Application Reference: 2026/0362

Site Address: 4 Hazelwood, Smithies, Barnsley, S71 2GE

This application seeks retrospective planning permission for the erection of a single storey rear extension to the north-western elevation of the original dwelling, attached to the south-western side elevation of the approved extension, and alterations to rear garden levels.

AS MEASURED REAR ELEVATION
SCALE 1:100

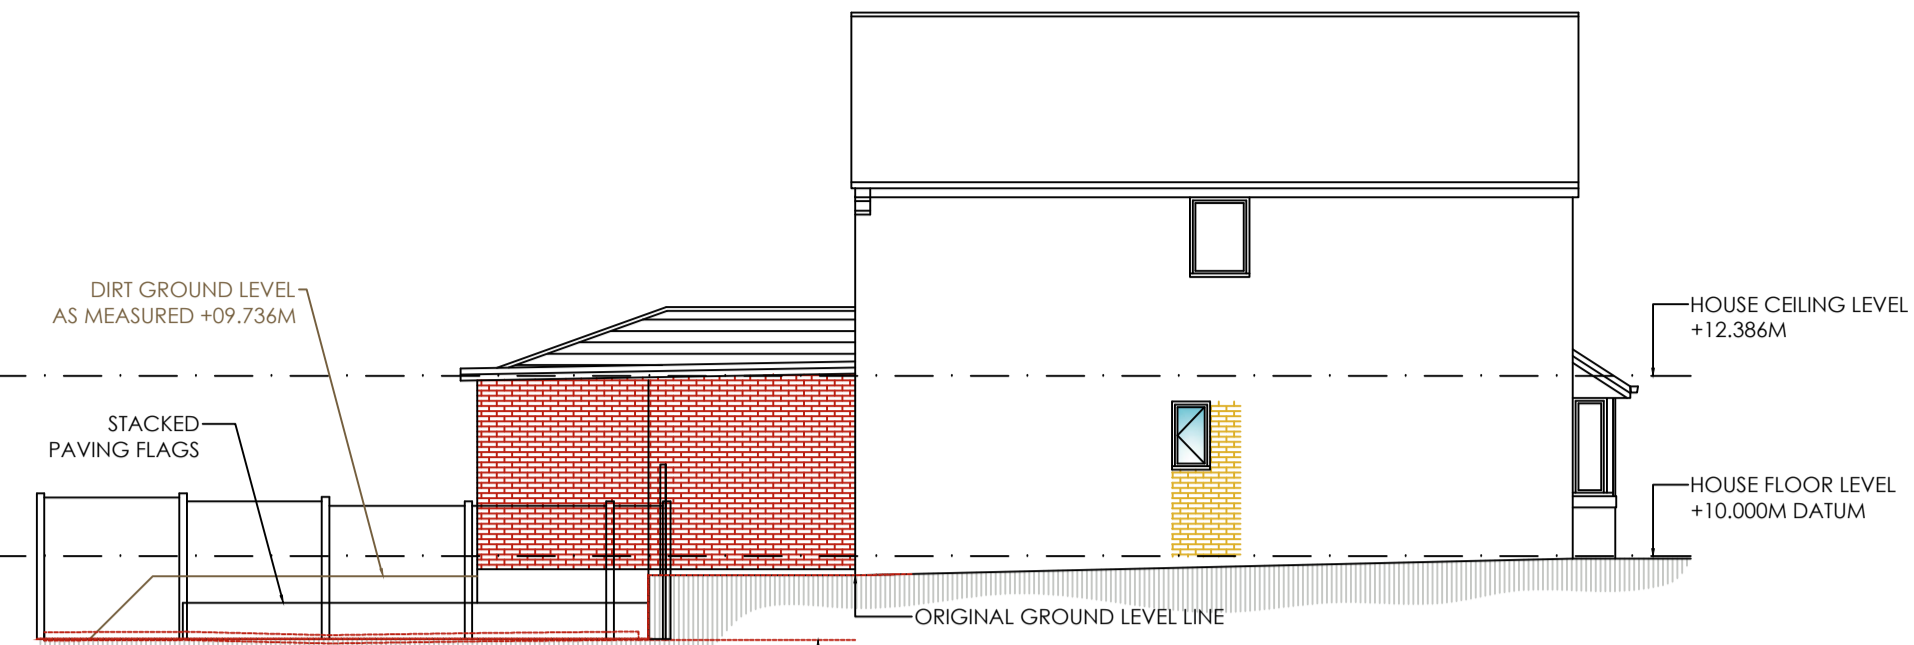
The original extension approved under application 2024/0868 with a hipped roof is considered to relate sympathetically to the host dwelling and the surrounding area. In contrast, the unauthorised extension with a lean-to roof appears as a later addition, with limited regard to the overall design. The relationship between the approved and unauthorised elements results in an awkward roof junction and an incongruous overall form, which detracts from the character and appearance of the property.

Furthermore, the fenestration of the unauthorised extension fails to reflect the proportions, positioning, and materials of the host dwelling, resulting in a lack of visual cohesion.

PROPOSED REAR ELEVATION
SCALE 1:100

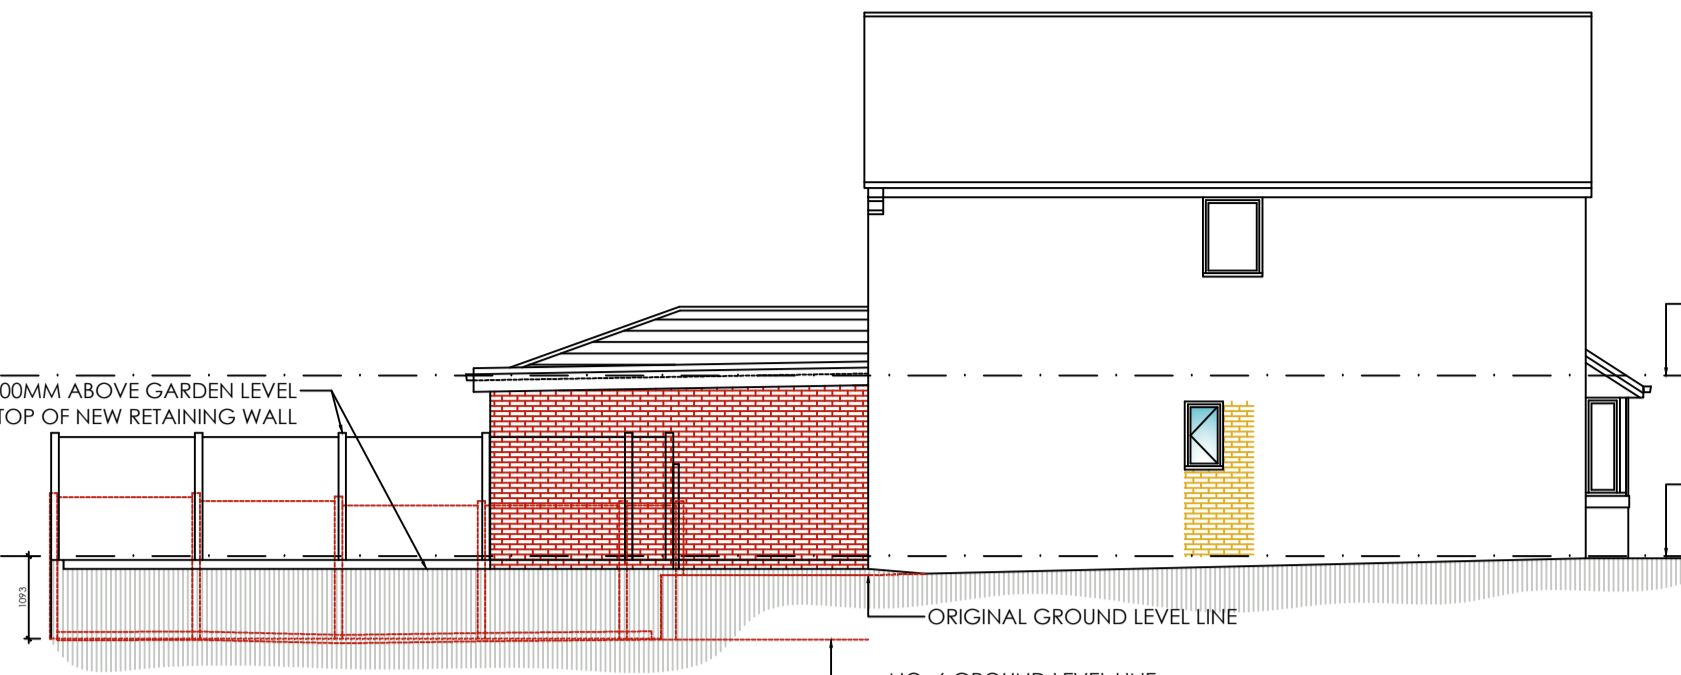
In assessing the proposal the design is considered to be poor with an incongruous relationship between the approved and unauthorised elements resulting from an awkward roof junction and an asymmetrical overall form, which detracts from the character and appearance of the property and is overall not in conformity with the adopted SPD House Extensions and Other Domestic Alterations. The resulting visual impact of the development is considered to result in harm to the character and appearance of the area, contrary to Local Plan Policy D1 and paragraphs 135 and 139 of the NPPF. This carries significant weight against the proposal.

The unauthorised extension appears as a later addition, with limited regard to overall design. The relationship between the approved and unauthorised elements results in an awkward roof junction and an incongruous overall form, which detracts from the character and appearance of the property. Furthermore, the fenestration of the unauthorised extension fails to reflect the proportions, positioning, and materials of the host dwelling, resulting in a lack of visual cohesion. Although the extension is located to the rear, it is visible from public vantage points and as such, the development is considered to result in harm to the character and appearance of the area, contrary to Local Plan Policy D1 and paragraphs 135 and 139 of the NPPF.

PROPOSED SIDE ELEVATION
SCALE 1:100

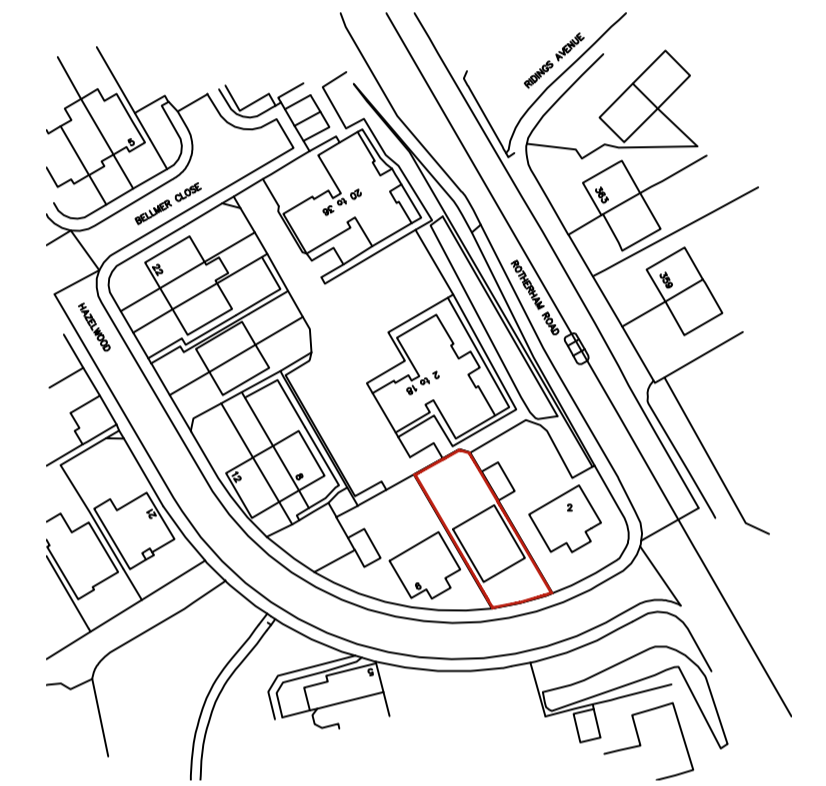
Following the development, excavated material has been deposited across the rear garden, resulting in an overall increase in ground levels. The rear garden of the application property now sits approximately 1m higher than the neighbouring property at No. 6.

This increase in levels has created opportunities for overlooking into the neighbouring garden and towards ground floor habitable room windows. A site visit confirmed that clear views into the neighbouring garden are achievable, although direct views into habitable room

In an attempt to mitigate this, the applicant has proposed the erection of a 1.8m high timber fence along the boundary between the two properties. However, due to the level difference between the properties, the fence would appear significantly higher, approximately 2.7m in height, when viewed from No. 6 Hazelwood. This would result in an overbearing and visually dominant boundary treatment, to the detriment of the amenity of neighbouring occupiers.

The regrading of the land is considered to result in significant harm to residential amenity of the neighbouring property, through increased levels of overlooking and loss of privacy. The proposed mitigation measures of a 1.8m fence which would appear as approximately 2.7m high from the neighbouring property would result in an overbearing and visually dominant boundary treatment, to the detriment of the amenity of neighbouring occupiers, contrary to Local Plan Policy GD1. This harm carries significant weight against the application.

The increase in garden levels would result in an increase in overlooking into the neighbouring garden and towards ground floor habitable room windows to a detrimental level, contrary to Local Plan Policy GD1 and SPD

The 1.8m high timber fence proposed along the boundary with the neighbouring property in an attempt to mitigate overlooking of the neighbouring dwelling and private amenity space, would result in an overbearing and visually dominant boundary treatment, to the detriment of the amenity of neighbouring occupiers and contrary to Local Plan Policy GD1 and SPD
